January 11, 2019

Site: Fiesta Kia-7400 Lomas Blvd NE

**Re: Drainage Ordinance (14-5-2-1) Violations for Erosion and Sediment Control**

FIESTA KIA ALBUQUERQUE		CITY, COUNTY, STATE
ALBUQUERQUE, BERNALILLO COUNTY, NM		CITY, COUNTY, STATE
06/19/18	DATE	 inspections Plus, Inc.
C. DURKIN	DRAWN BY

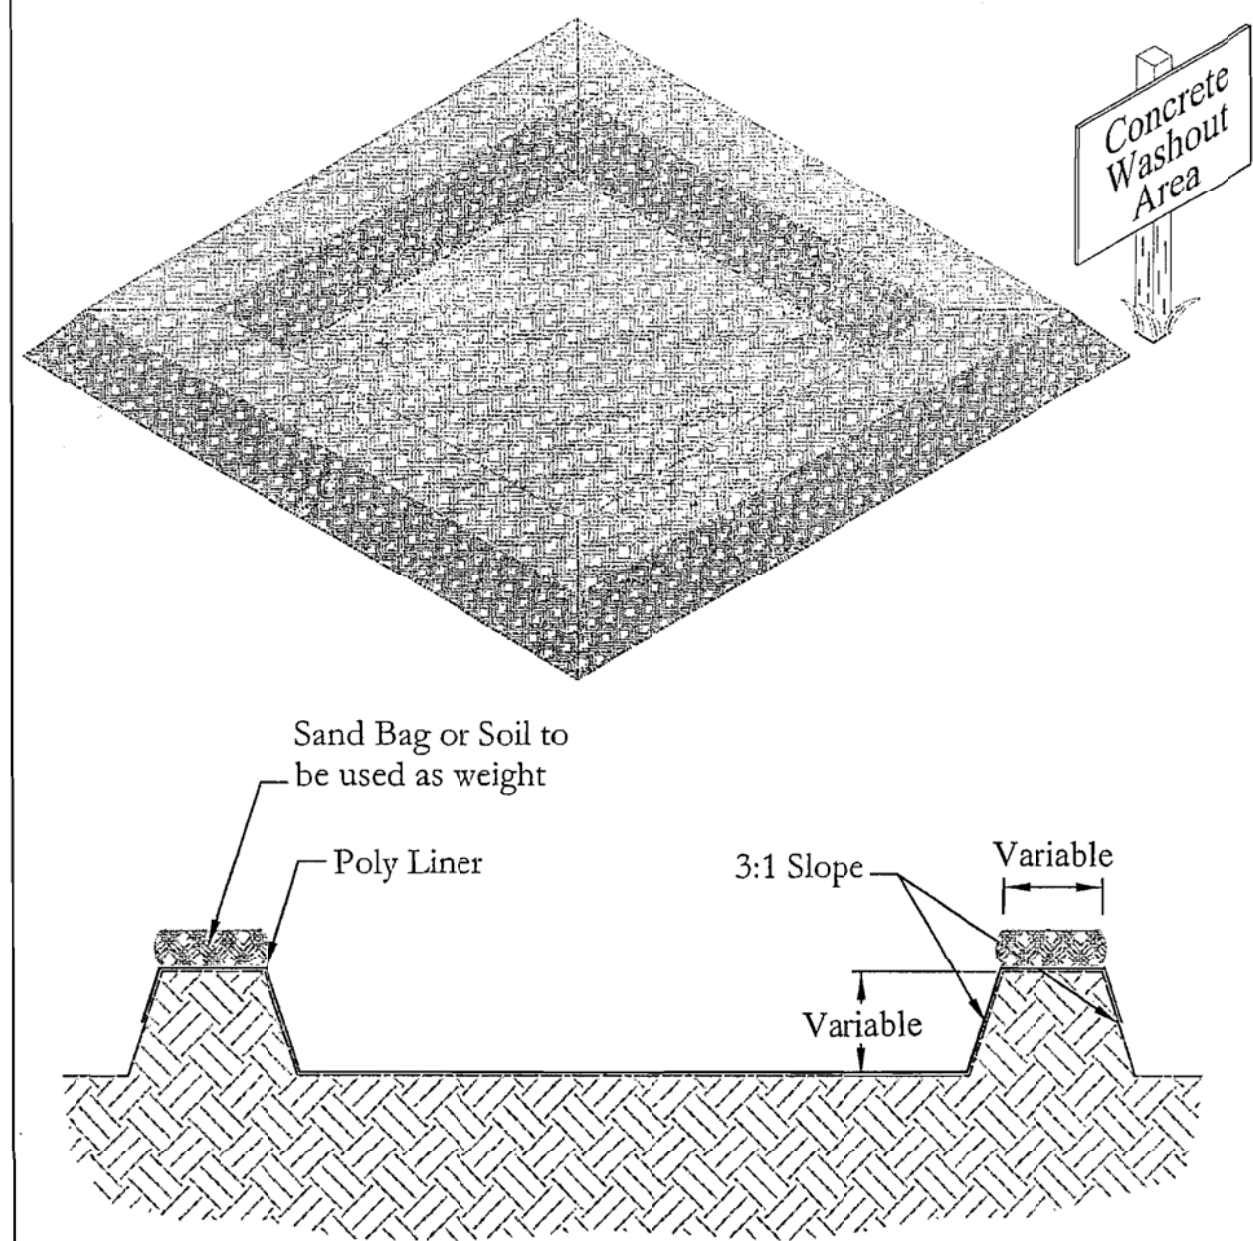
1. Sediment leaving the site and running down the gutter on Lomas Blvd.
2. Inadequate management of offsite flows.

Sediment leaving site and entering Lomas Blvd.

Pipe from offsite basin discharging into the site.

This area is adjacent to and uphill of the Vehicle Tracking Control pad.

1. Prevent sediment from leaving the site and running down the gutter on Lomas Blvd.
2. Manage offsite flows so they don't flow into the dirt/mud then into Lomas Blvd.
